WEST SUSSEX COUNTY COUNCIL CONSULTATION

TO:	Arun District Council FAO: Hannah Kersley
FROM:	WSCC – Highway Authority
DATE:	7 October 2026
LOCATION:	Local Centre and Phase 6b Hampton Park Littlehampton
SUBJECT:	LU/250/25/RES Approval of reserved matters following the grant of LU/47/11/ (amended by LU/182/15/PL) for 111 No dwellings, 1472sqm of retail floor space, 418sqm of community centre floor space, a civic public open space (0.35ha), a community car park and a super LEAP (incorporating fitness equipment / trail) comprising 0.62ha. an amendment to the above application dated 26th June 2026 relating to:- Substitute drawing pack plans and additional plan - received on 21/09/2026.
DATE OF SITE VISIT:	n/a (desktop study undertaken – site visited previously)
RECOMMENDATION:	More Information Required

This is the **second** WSCC Highways response to the above planning application seeking approval of reserved matters following the grant of LU/47/11/ (amended by LU/182/15/PL) for 111 No dwellings, 1472sqm of retail floor space, 418sqm of community centre floor space, a civic public open space (0.35ha), a community car park and a super LEAP (incorporating fitness equipment / trail) compr

Status:	PLANNING	Rev. -
Scale. 1-500 @ A1	Project No. 011042	Dwg No. PL - 100
Date: 28.11.2025	Drawn By. ST	Chk. AS

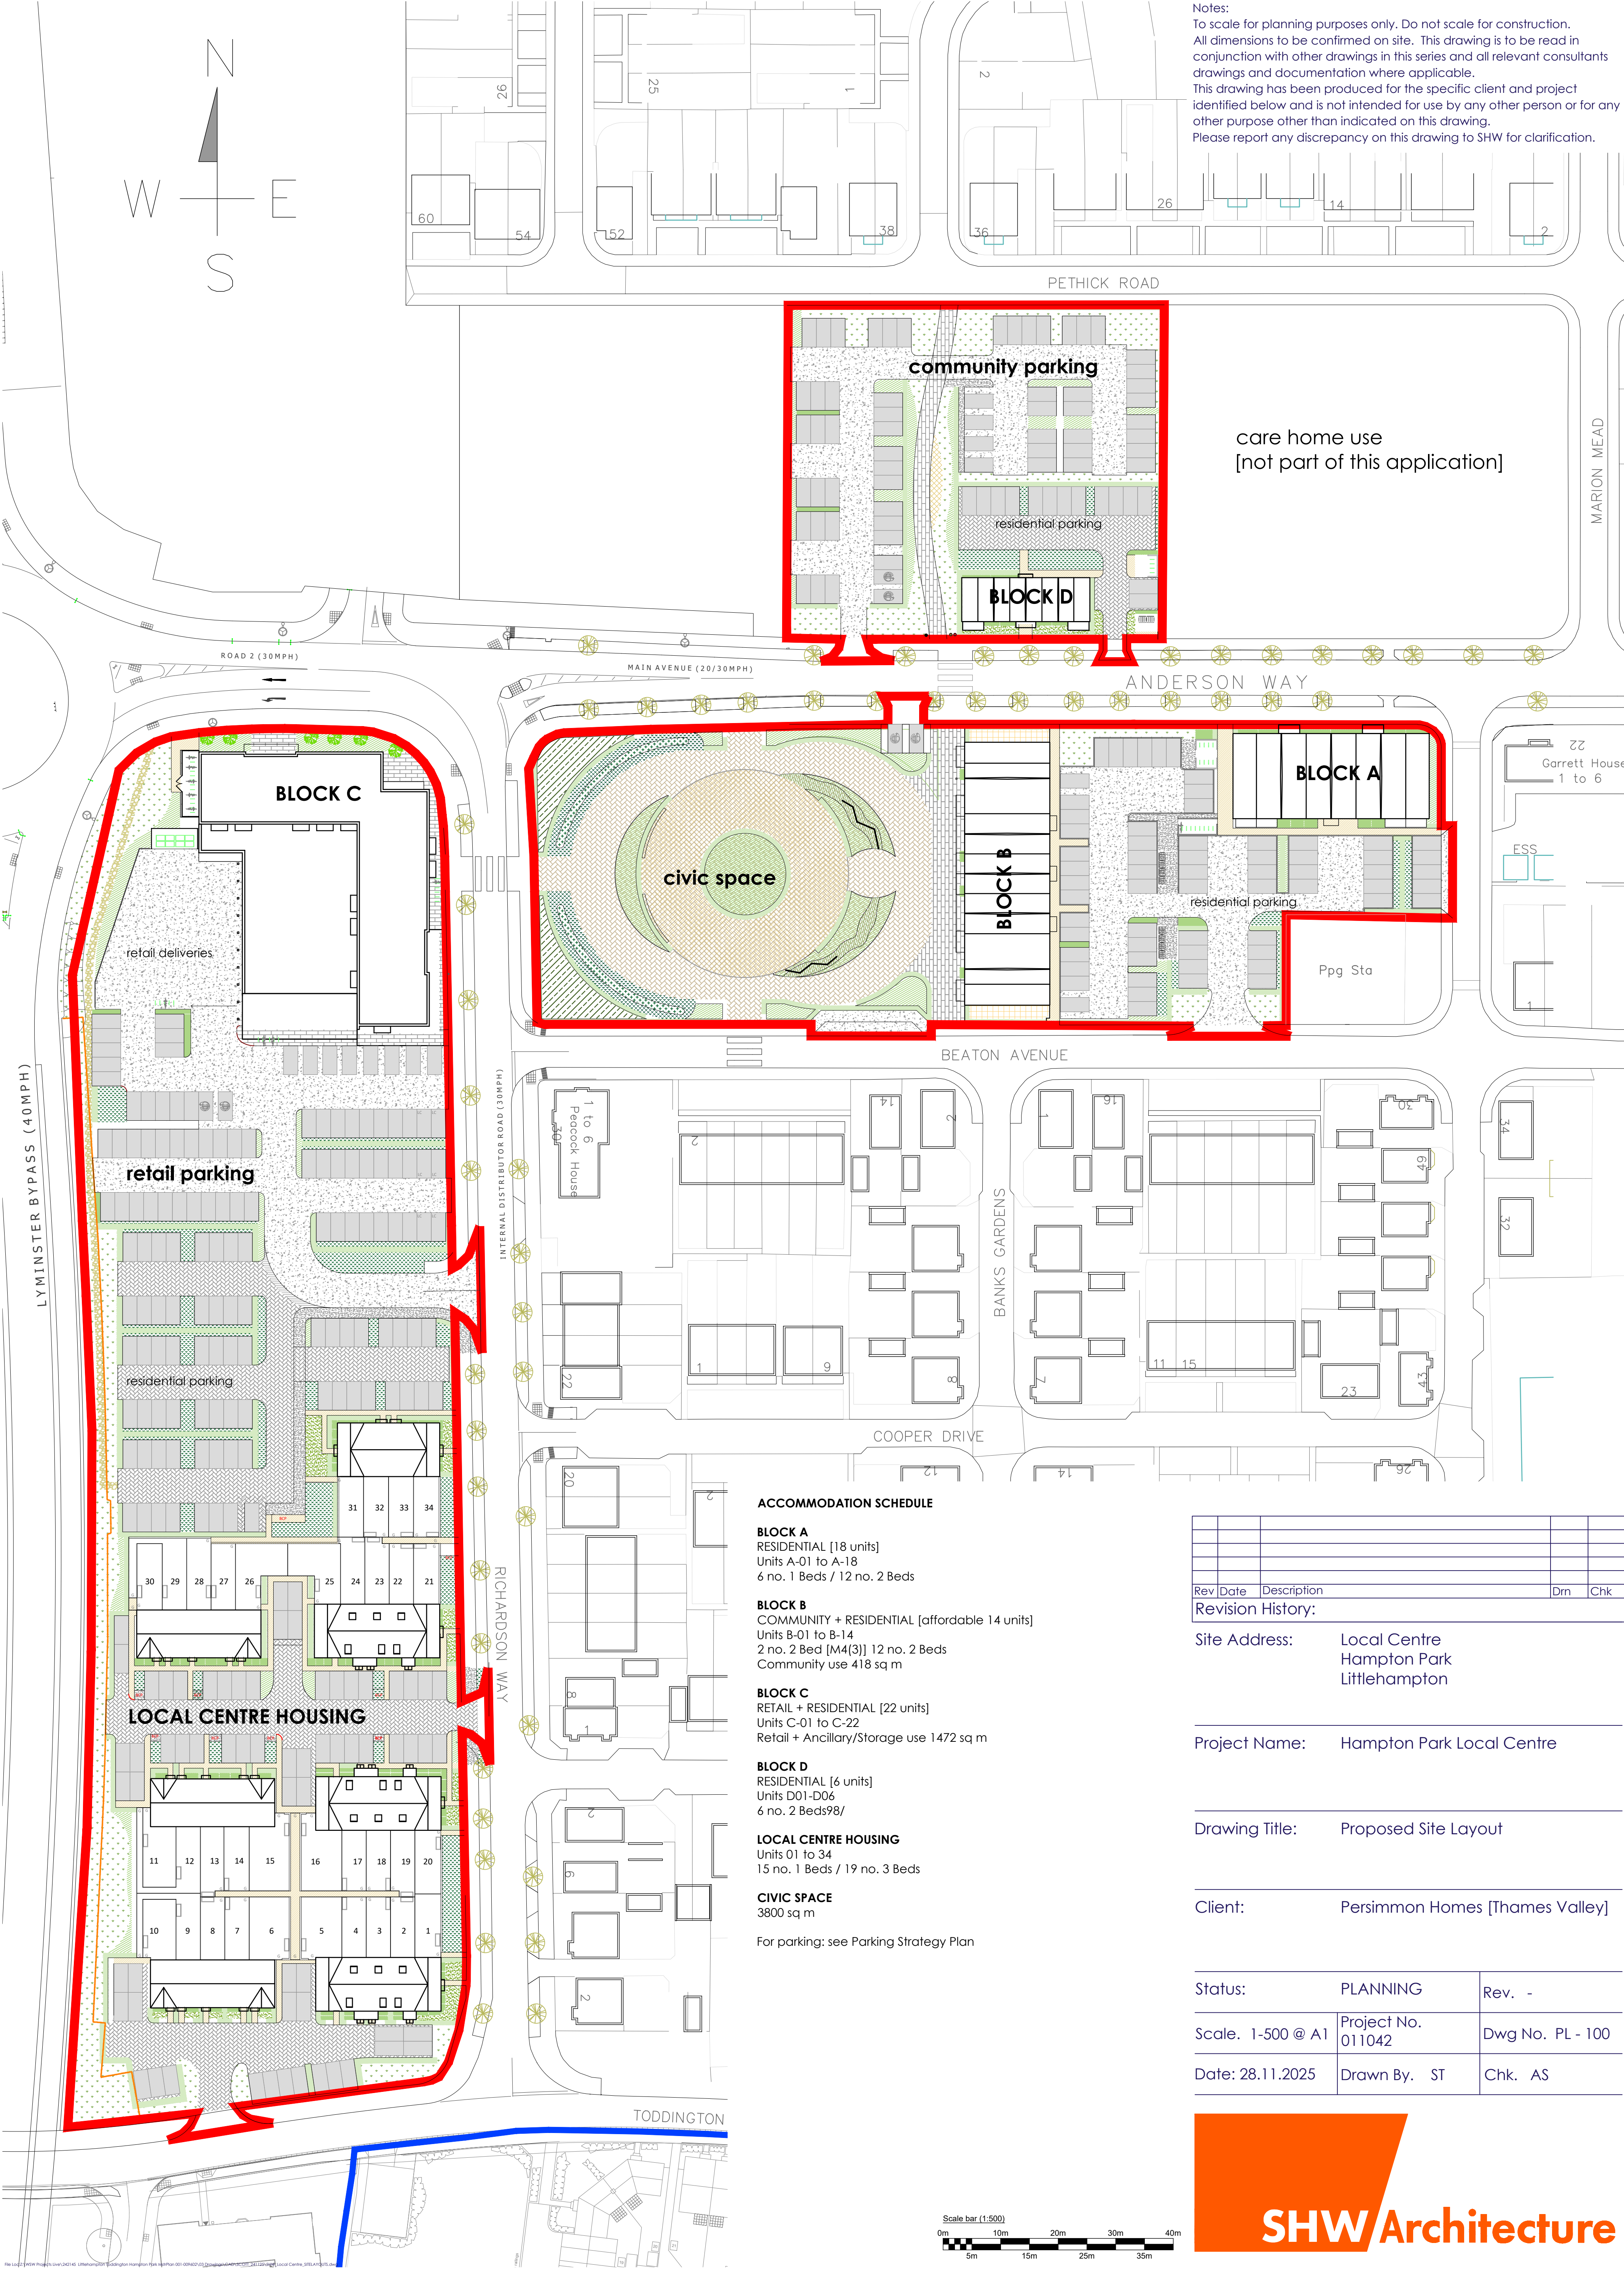
- Zebra-style crossing points are shown at three locations (Richardson Way, Anderson Way and Beaton Avenue). While the plans might show architect's interpretations of zebra-style crossings, if they are to be provided, they will need to be designed in accordance with relevant design guidance/standards and shown as such on amended drawings. They will also need to be Safety Audited. A DRAFT Decision Log in tabular form should accompany the Audit. Also, TROs might also be required for them. Applicant to clarify what they are and whether they intend to provide them. ***No reply to this appears to have been made. Applicant to attend to.***

- Please explain what 'community parking' area is for. ***No reply to this appears to have been made. Applicant to attend to.***
- Access to Toddington Lane for southern part of the development would be a new access point. As such, visibility splays, appropriate to the posted speed limit on Toddington Lane and taken from a 2.4m 'x' distance, need to be shown on an amended drawing. ***This has been shown on General Arrangement Drawing PHLITTLECC.2/102 Rev 'P3', albeit slightly incorrectly in the trailing traffic direction (it should be taken to the kerb face of the carriageway). However, it does demonstrate that 43m would be achievable in this direction.*** It is also recommended that separate pedestrian access be shown from Toddington Lane to that part of the development. ***This is not shown. Applicant to attend to.***

- Applicant should explain why two EV parking spaces are shown accessing onto Anderson Way and shown close to the possible zebra-style crossing. Given that they would require reversing across the adjacent shared foot and cycle path, it is recommended that they be removed and moved to one of the adjacent car parks instead. ***These have not been changed since the previous comments were made. Applicant to attend to.***
